**WELWYN HATFIELD BOROUGH COUNCIL
EXECUTIVE DIRECTOR - PLANNING, PUBLIC PROTECTION AND GOVERNANCE**

DELEGATED APPLICATION

Application No: 6/2022/1793/HOUSE
Location: Postern Gate Farm Newgate Street Village Hertford Hertfordshire SG13 8QR
Proposal: Erection of a single storey front extension
Officer: Ms Elizabeth Mugova

Recommendation: Granted

**[02] PROPOSED ROOF PLAN**

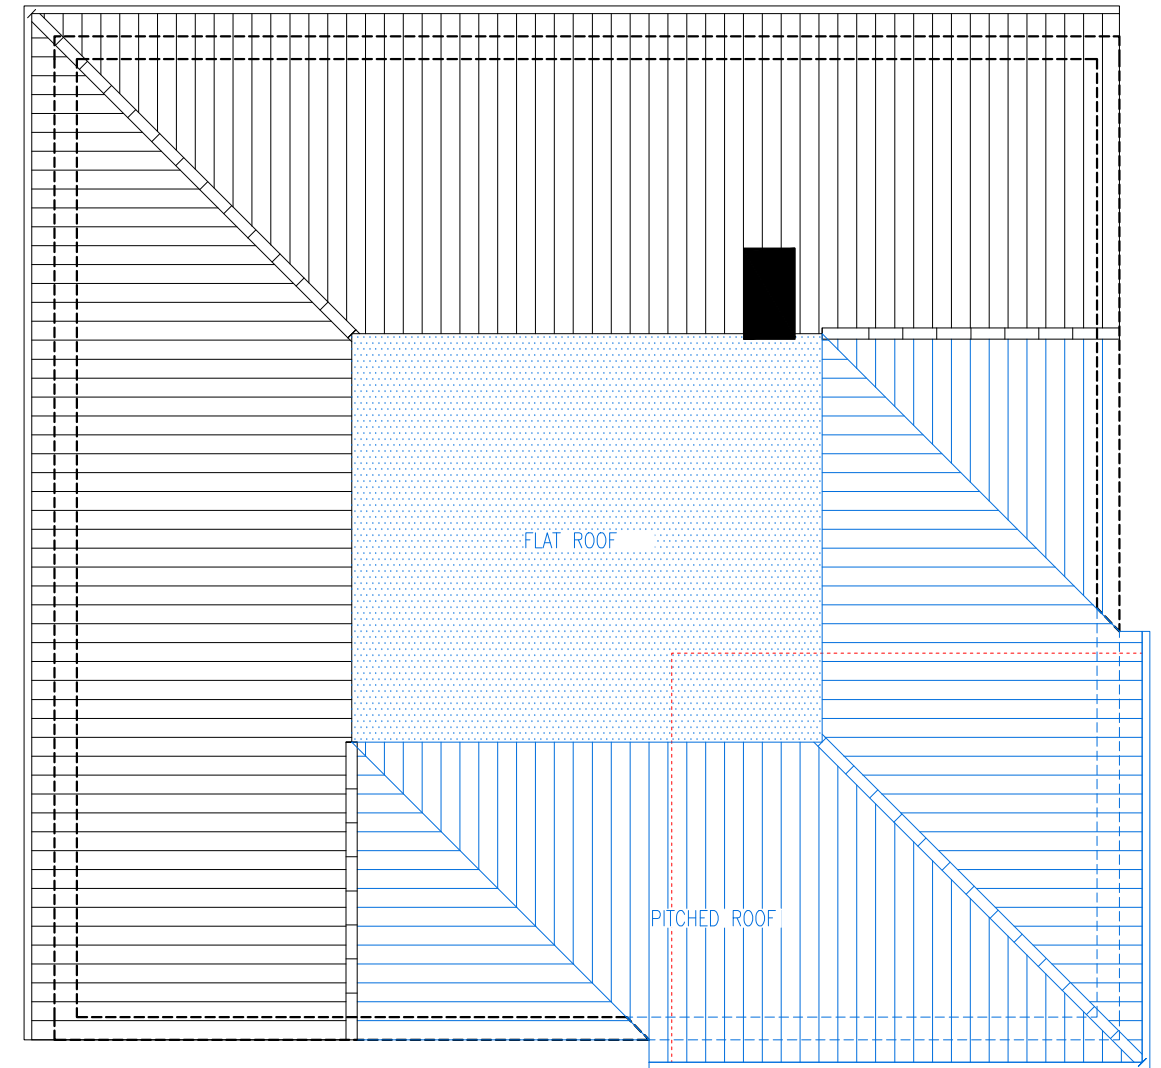
The resultant dwelling would feature a crown roof. Given the scale and location of the proposed development a crown roof would be acceptable. However, in terms of visual amenity and quality of design, some crown roofs are not attractively designed and can significantly detract from the appearance of a dwelling. As such it is considered reasonable to condition details and a section to show the flat roof is stepped down and concealed behind the surrounding pitched roof to ensure its impact in terms of visual amenity would be limited.

1. No development above ground level shall take place until details of the proposed crown roof, including a cross-section drawing, has been submitted to and approved in writing, by the Local Planning Authority. The details must clearly show that the flat roof is stepped down and concealed behind the surrounding pitched roof or ridge tiles. Subsequently the development must not be carried out other than in accordance with the approved details.
